Our Case Number: ABP-317742-23

Re: BusConnects Bray to City Centre Core Bus Corridor Scheme
Bray to Dublin City Centre.

BRAY SCHEME No 317742

The following is an observation on the above bus corridor scheme.

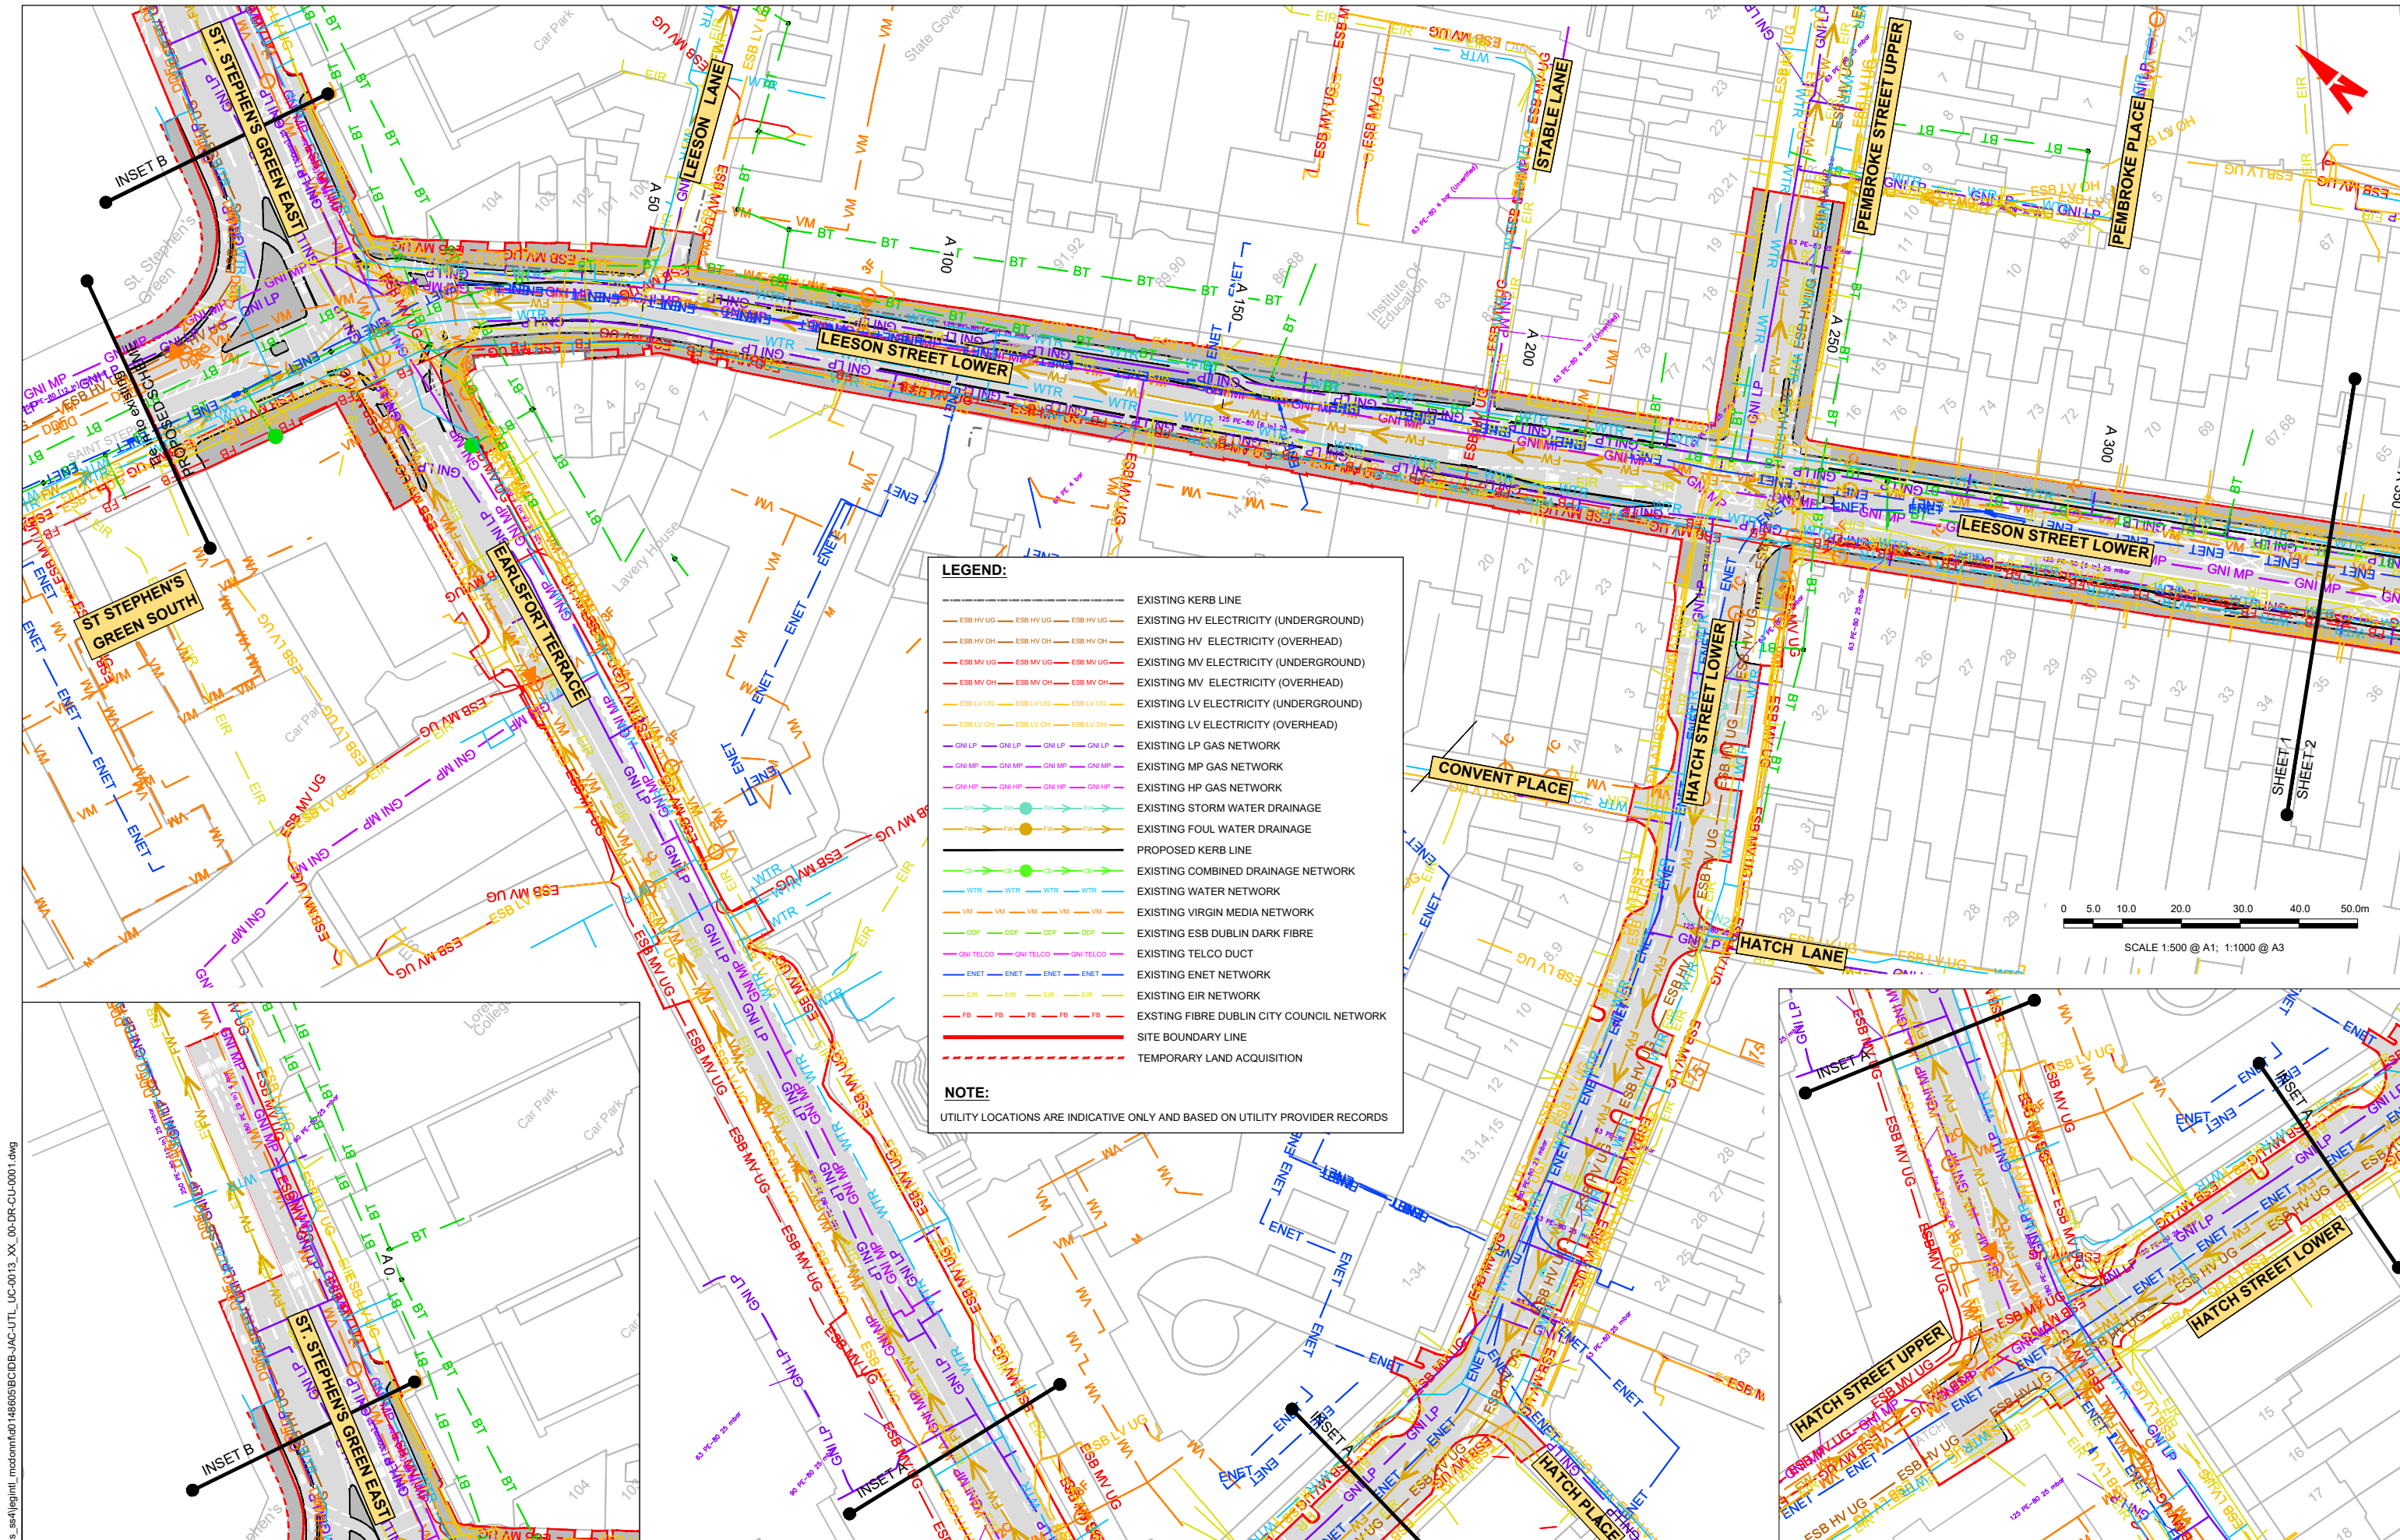
A bus gate is proposed at the end of Lower Leeson Street where it joins St Stephen's Green prohibiting any traffic into either part of St Stephen's Green between 6am and 10am morning and 4pm and 8pm afternoon. I note the permitted traffic here does not include taxis. See map 01 of 54. The exclusion of taxis (which I probably support in principle) is different from other gates, which undermines the very weak justification for all gates having similar hours and terms ventured by NTA.

I object to the prohibition on traffic driving into St Stephen's Green South at this point. This is an important cross city route from east to west to allow traffic cross the south side. It has no relevance to traffic accessing the areas to the east of Dawson Street.

Drawing File Name: BCIDB-JAC-UTL_UC-0013_XX_00-DR-CU-0043 | Sheet Number: 43 of 54 | Status: A | Rev: M01

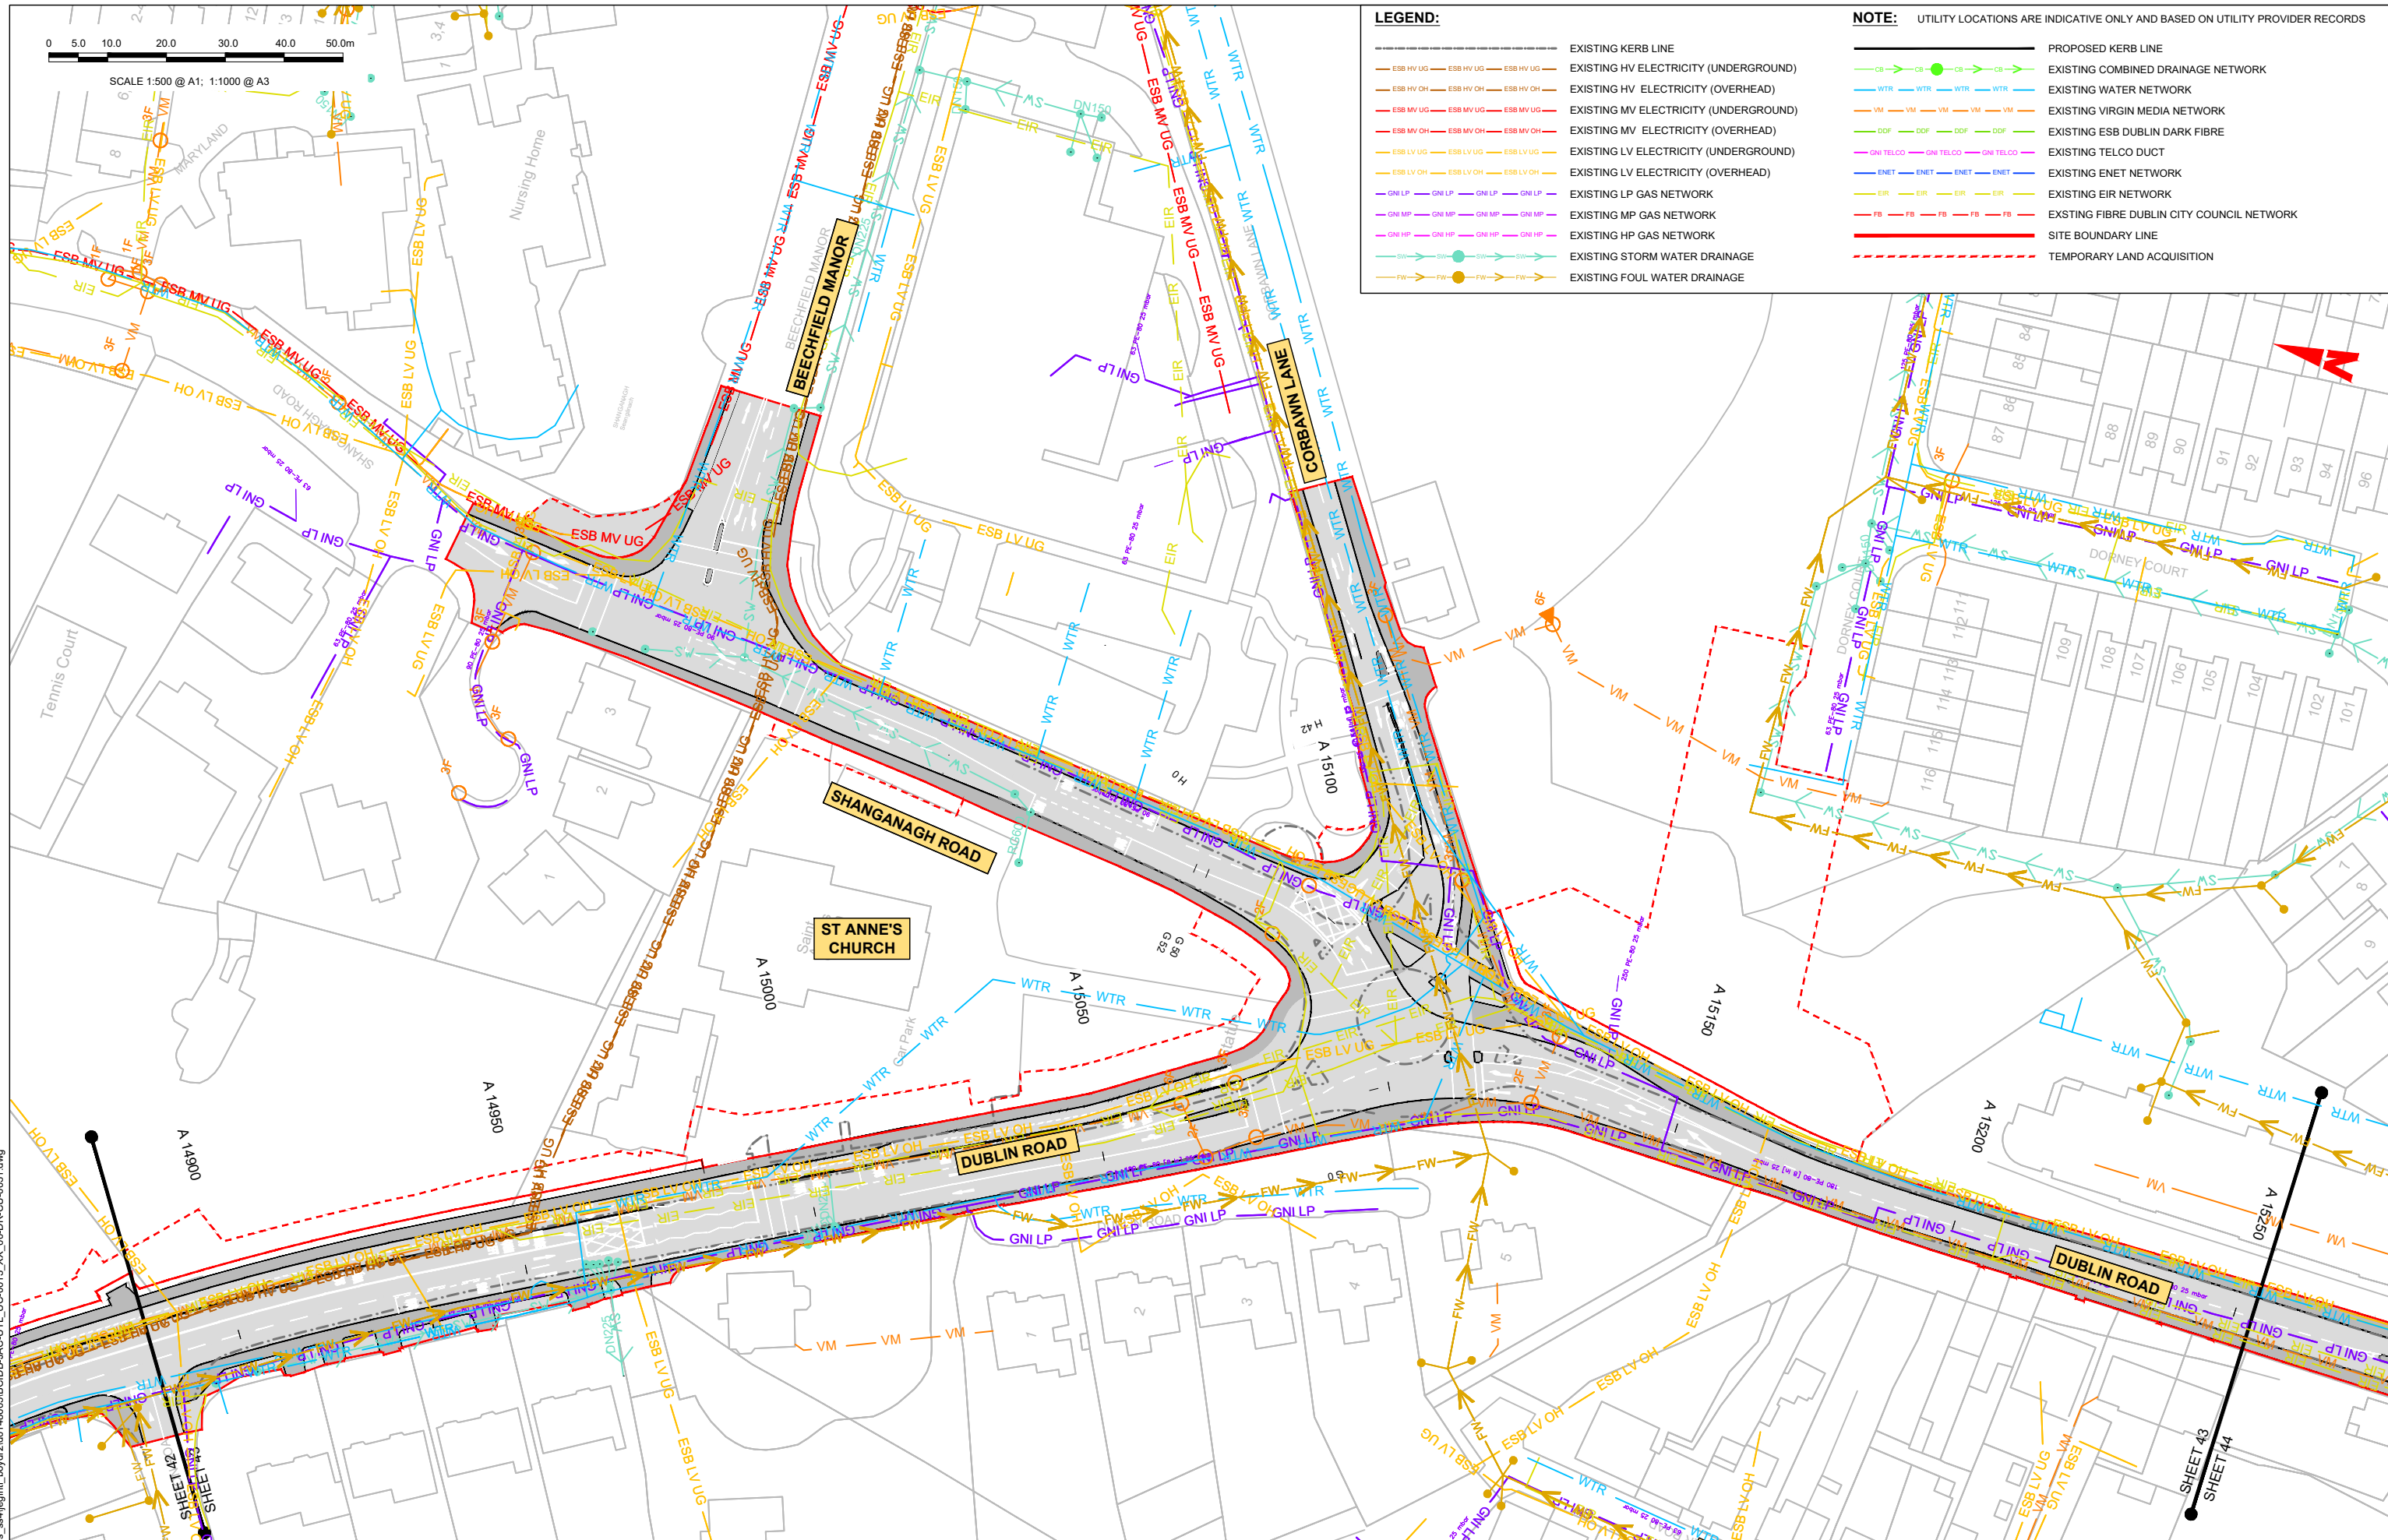
It is my understanding that there is a lot of local opposition to the removal of the roundabout at St Anne's Church (sheet 43 of 54). No doubt DMURS will be trotted out as the excuse for this. It is my clear reading of DMURS at page 105 that it has no application to small roundabouts nor does it apply where there are low pedestrian volumes. I quote "Where **large** roundabouts exist, road authorities are encouraged, as part of any major upgrade work, to replace them with signalised junctions or **retrofit** them so that {they} are more compact **and/or** pedestrian and cycle friendly, as is appropriate". I would like to give a fuller analysis but again the work required because of the poor presentation of traffic counts renders this impossible. Again this would be easy to assess if "IDASO" form prevailed. NTA have completely ignored the words I have highlighted. Undoubtedly if the signals are green, traffic will speed though the junction, whereas this roundabout forces it to slow down at the entrance to the village. An oral hearing would be useful on this topic.
